From: Contact Centre (CRM) <contact@ribblevalley.gov.uk>
Sent: 05 February 2026 16:32
To: Planning
Subject: Planning Application Comments - 3/2025/0988 FS-Case-795261489

Planning Application Reference No.: 3/2025/0988

Address of Development: Rodhill, 10 Clitheroe Road, Whalley. BB7 9AB

PROPOSED SIDE/PART SECTION ELEVATION

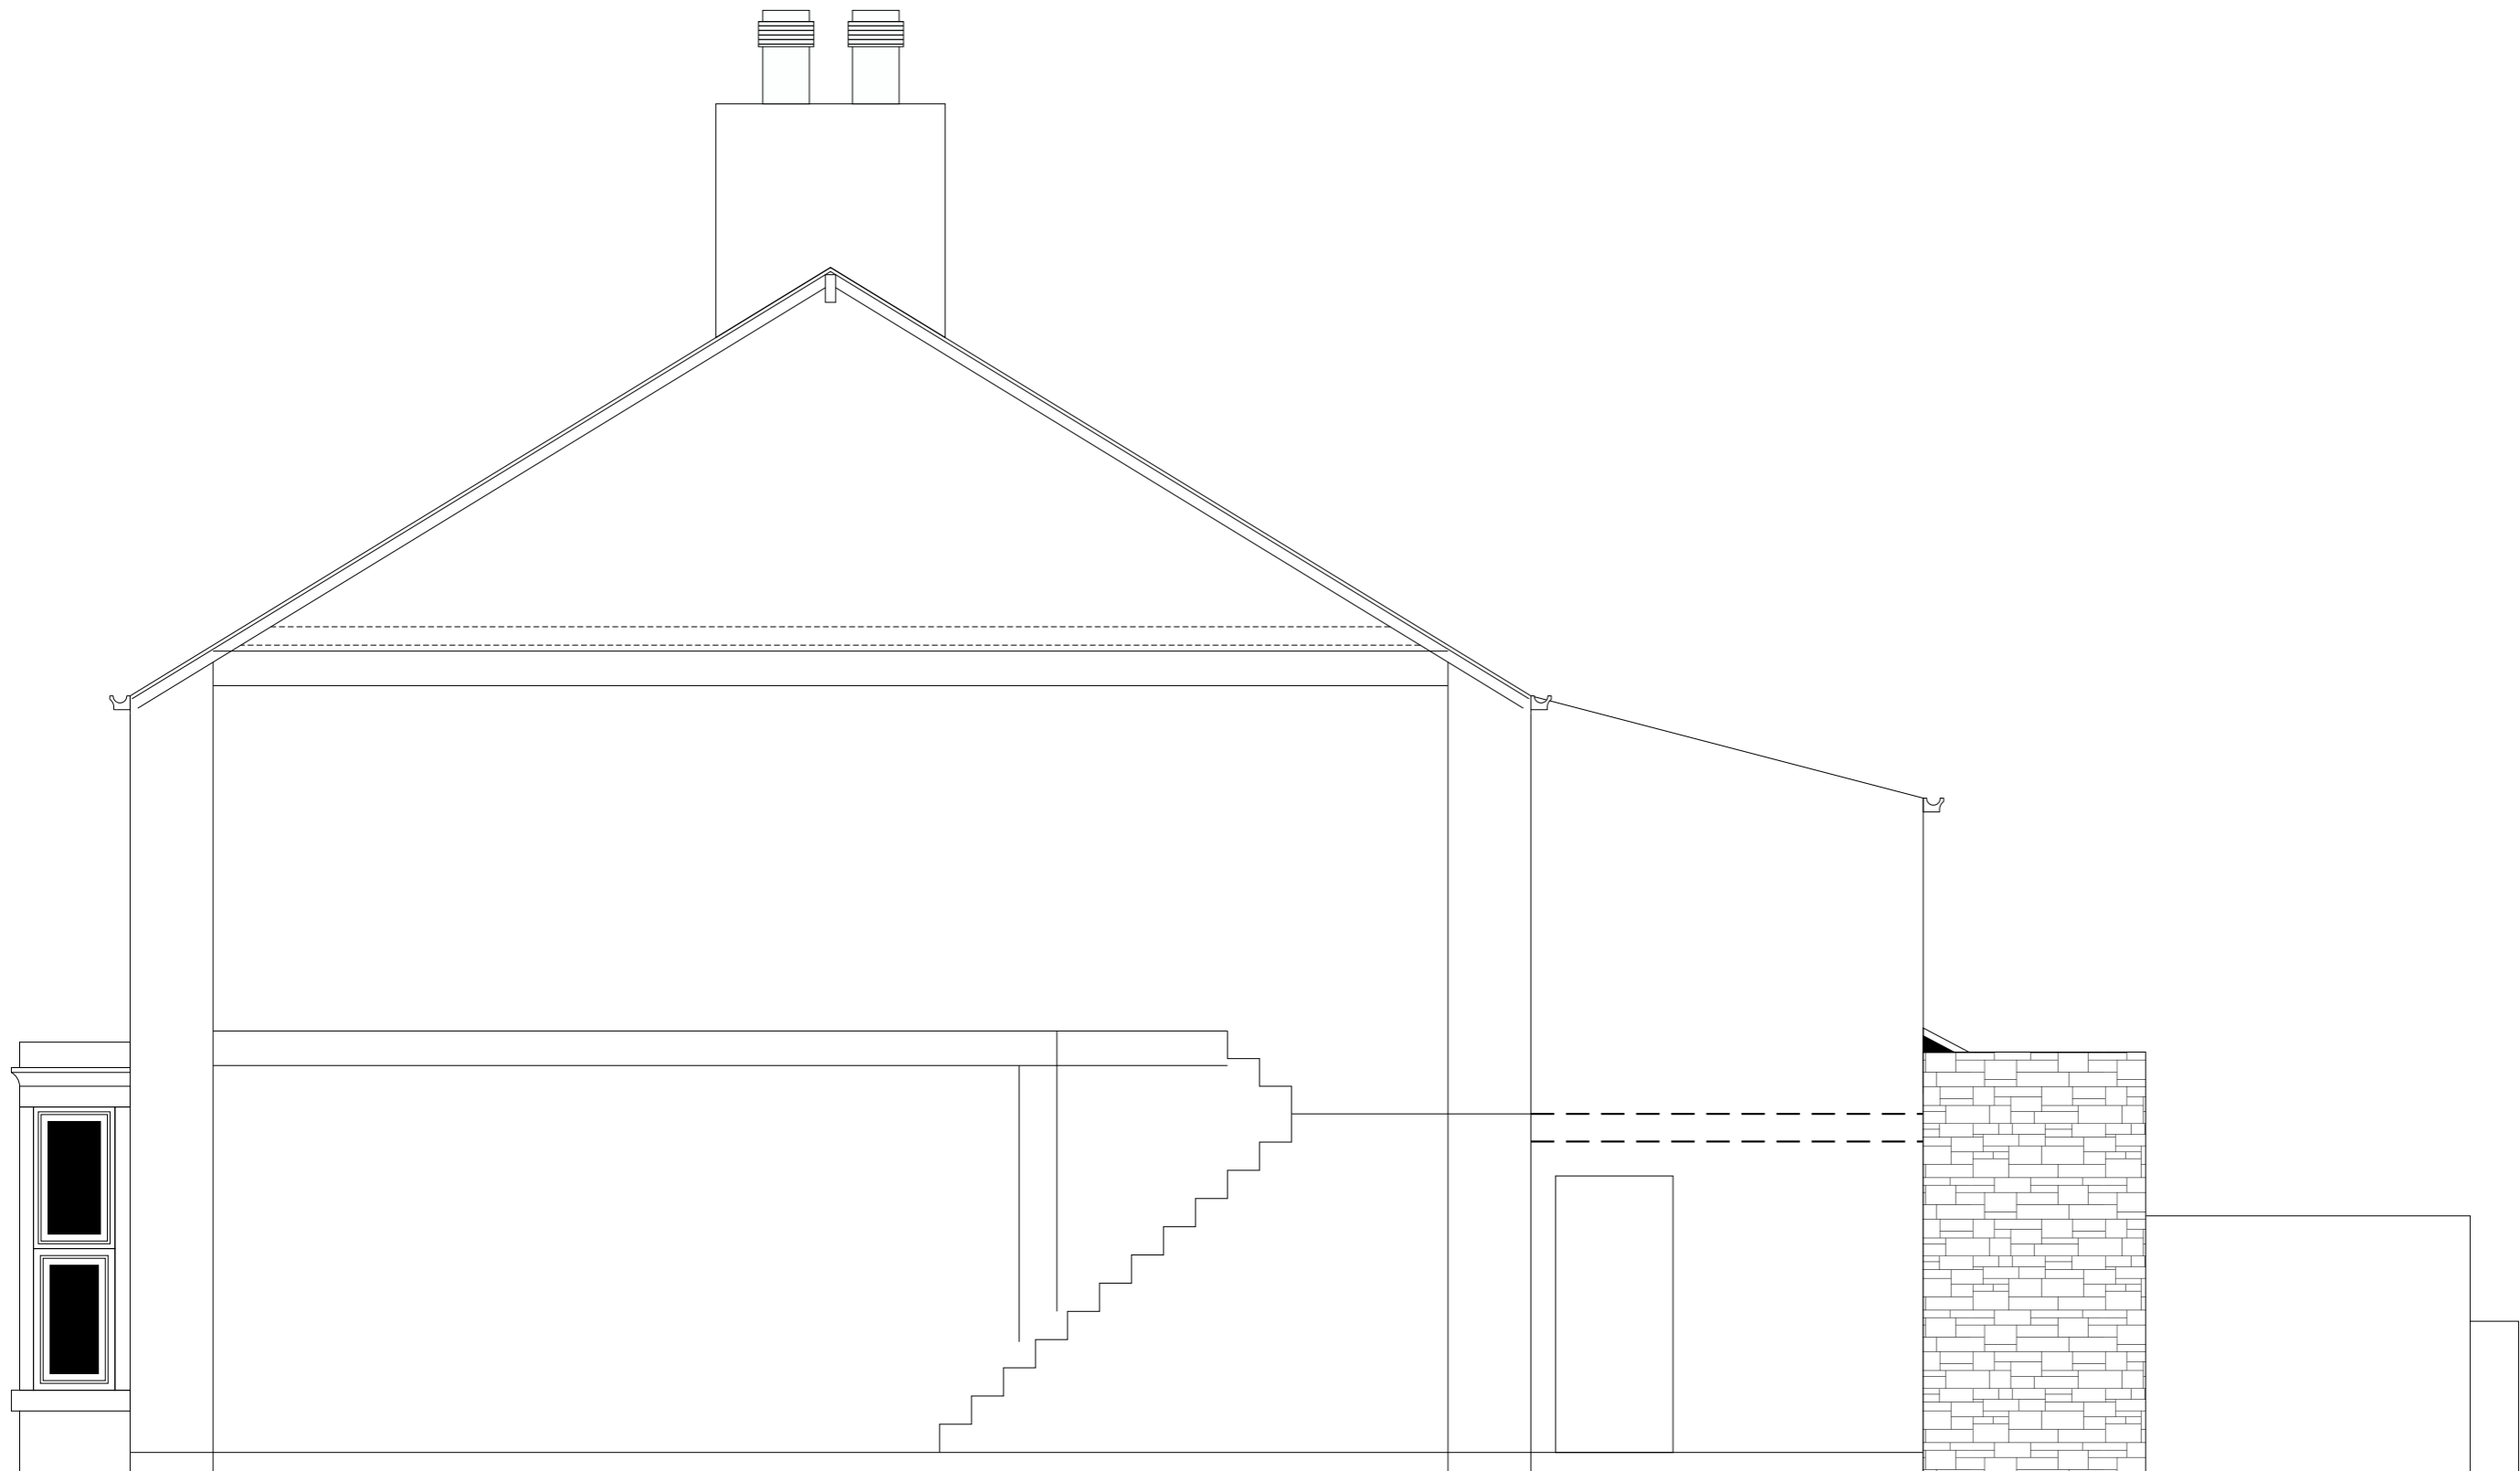
Comments: 1. I estimate that the proposed rear extension will extend [REDACTED]. (It is difficult for me to assess this as only the total length from the back wall of the main property at No10 has been given, however, I have [REDACTED].) At this point, the roof will be 3.07 high. I object to this on the grounds that it will result in considerable [REDACTED]. I would like consideration to be given to how the roof can be lowered or angled to [REDACTED].

3. I have been assured [REDACTED] that the face of the extended and raised party wall will be finished in stonework in keeping with vernacular architecture of this area. I have not seen any reference to this in the planning application. I would like to be assured of this in writing.

FIG 3

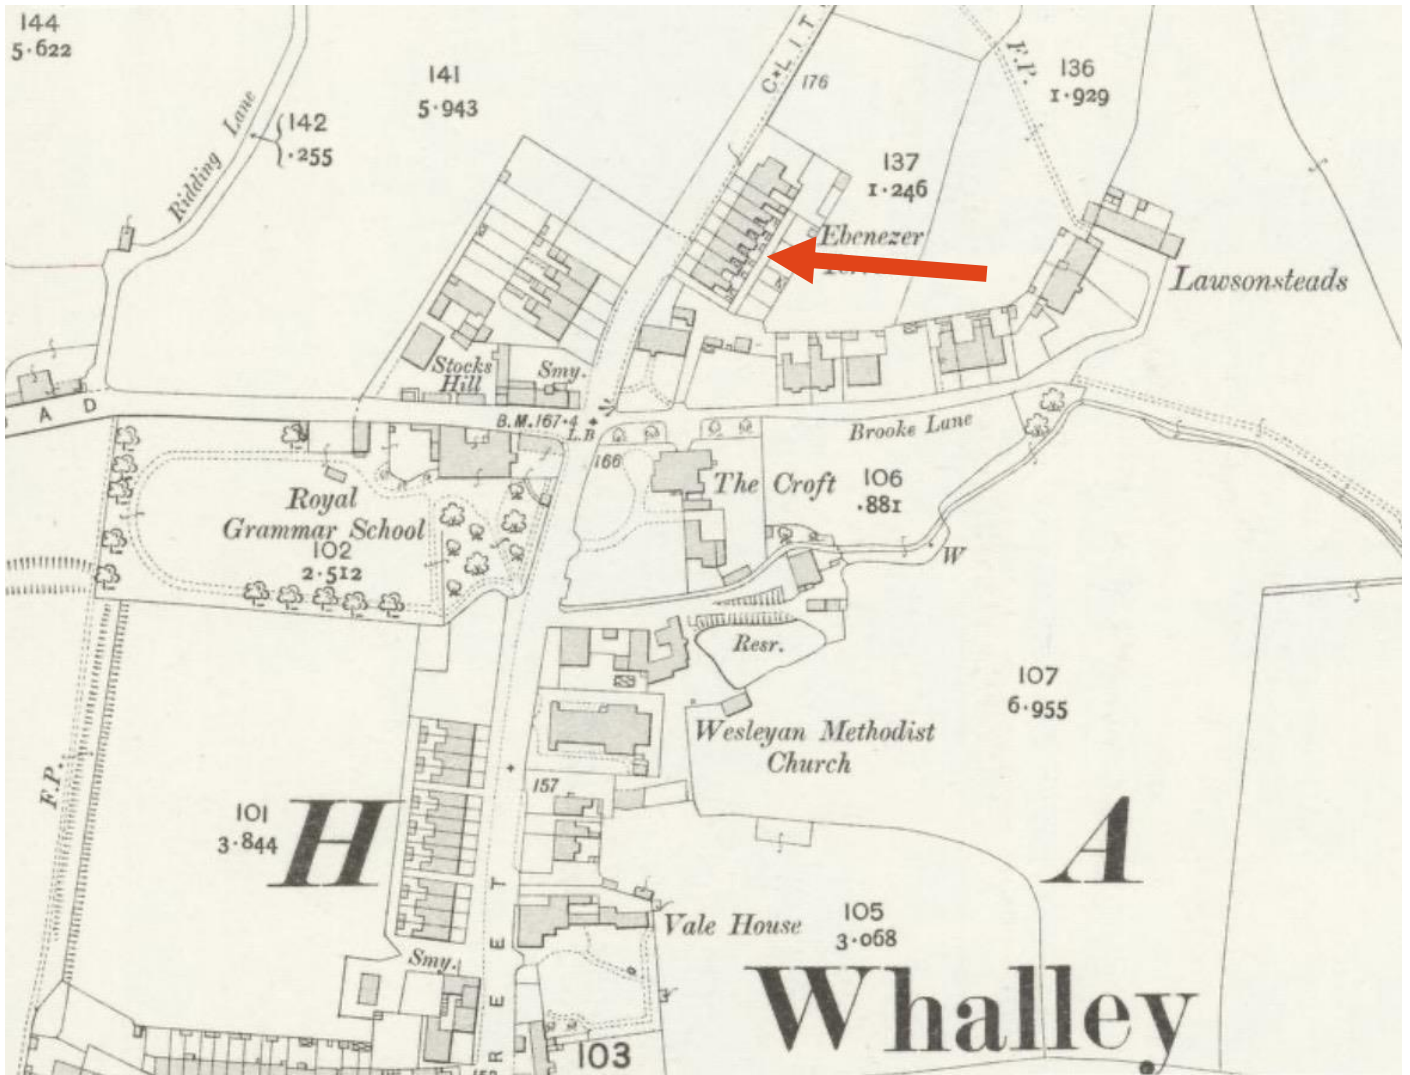
2. [REDACTED] which has been misunderstood by the architect when describing the outhouses on Ebenezer Terrace. That is a 'Tipler toilet' with a solid stone roof, typical of Lancashire terraces. These are sketchily marked on Annex Figure 3. The yard to Rodhill contains a similar shed [REDACTED]. I was told [REDACTED] that this was an old 'Wash-house'. The plans for changes to Rodhill do not indicate what is intended for this structure but I [REDACTED] Tipler toilet as a character feature and as something which should be conserved (in a conservation area) and would like it to be noted that some care will need to be taken over [REDACTED]. I can supply photographs of these structures if required.

PROPOSED REAR ELEVATION

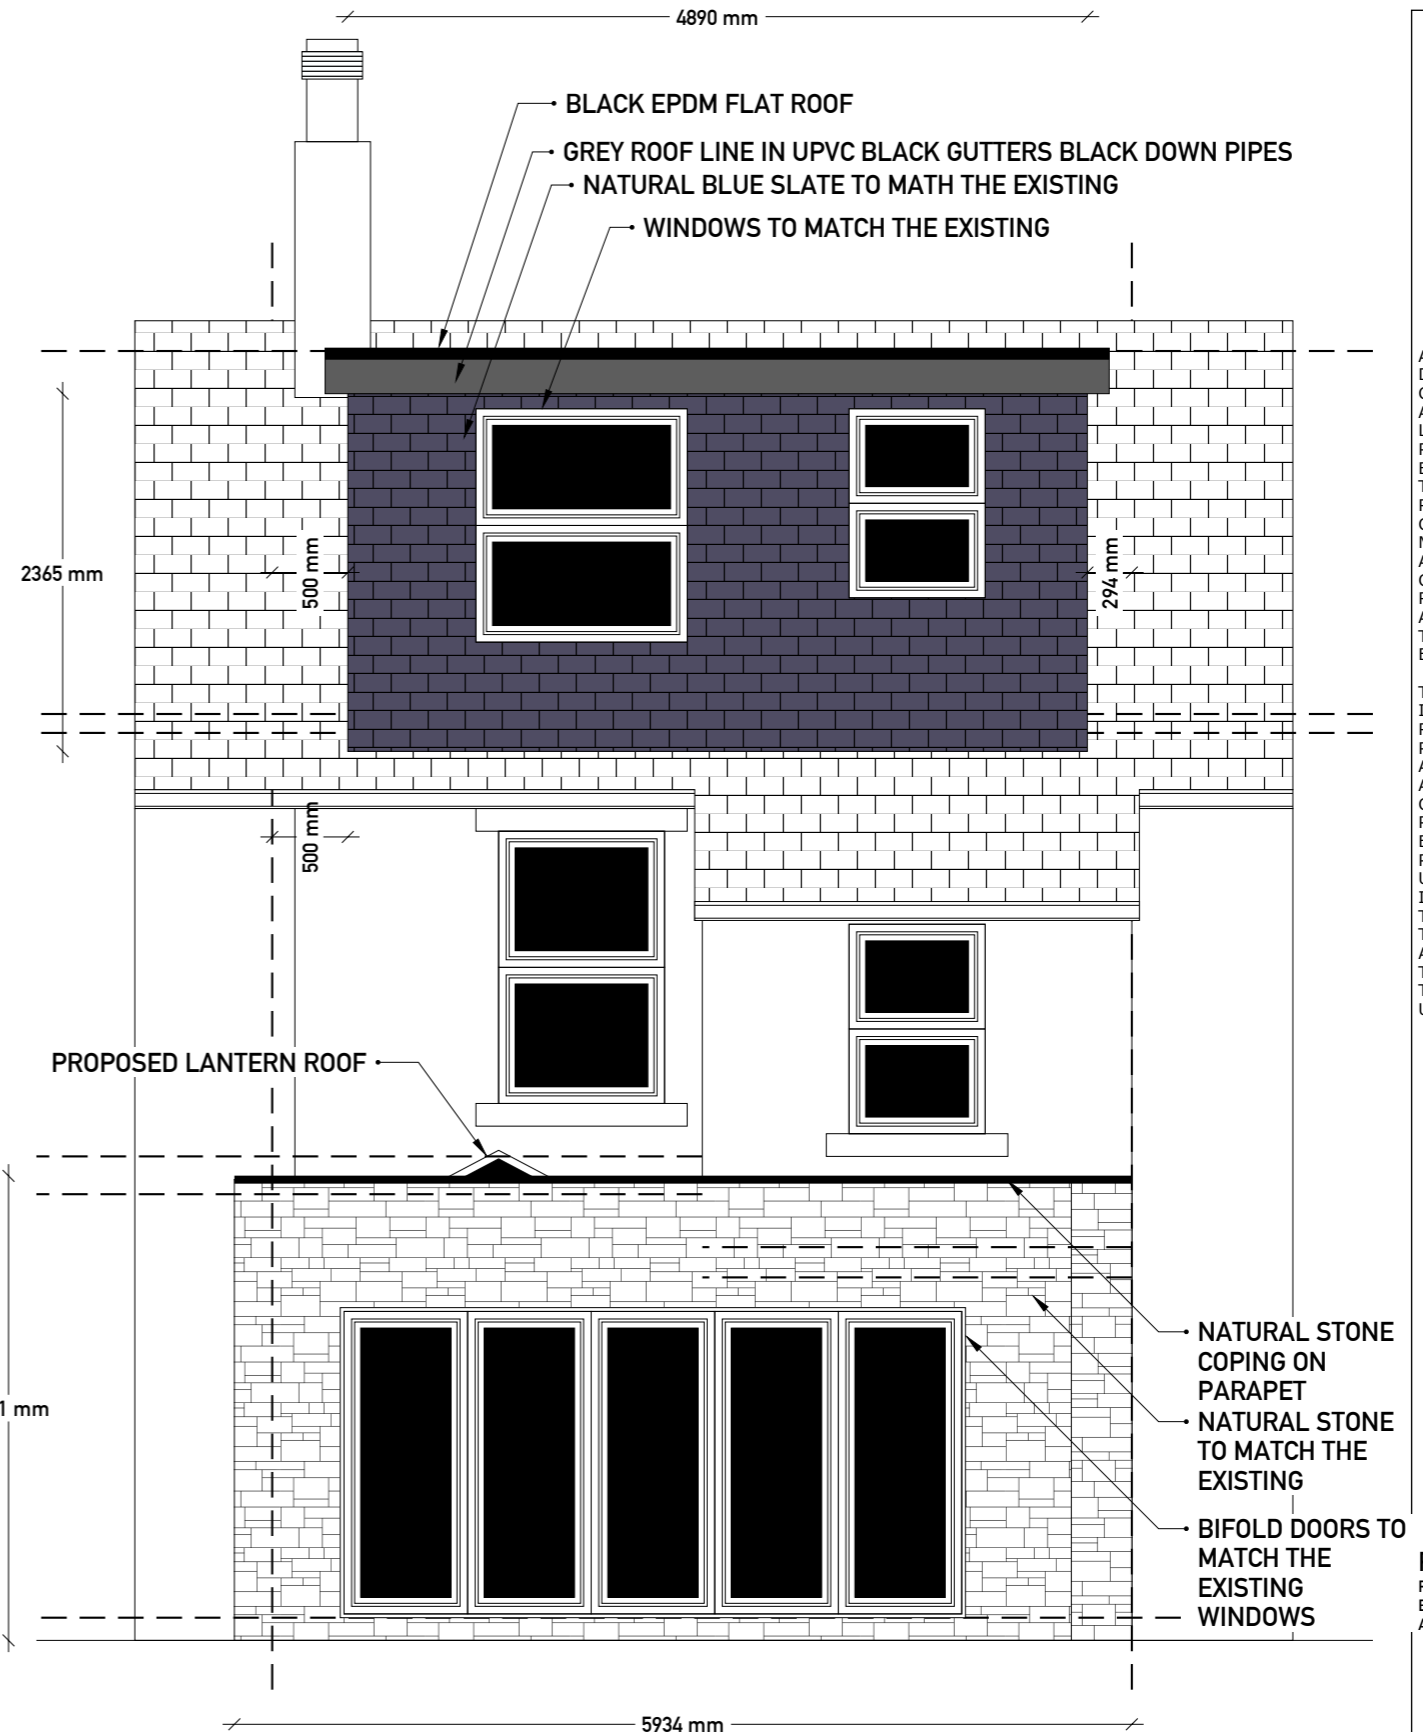
4. I am not sure that the design of the proposed extension in the roof at the rear of the No.10 is in keeping with the architectural period of the rest of the building- as would be more suitable in a Conservation area.
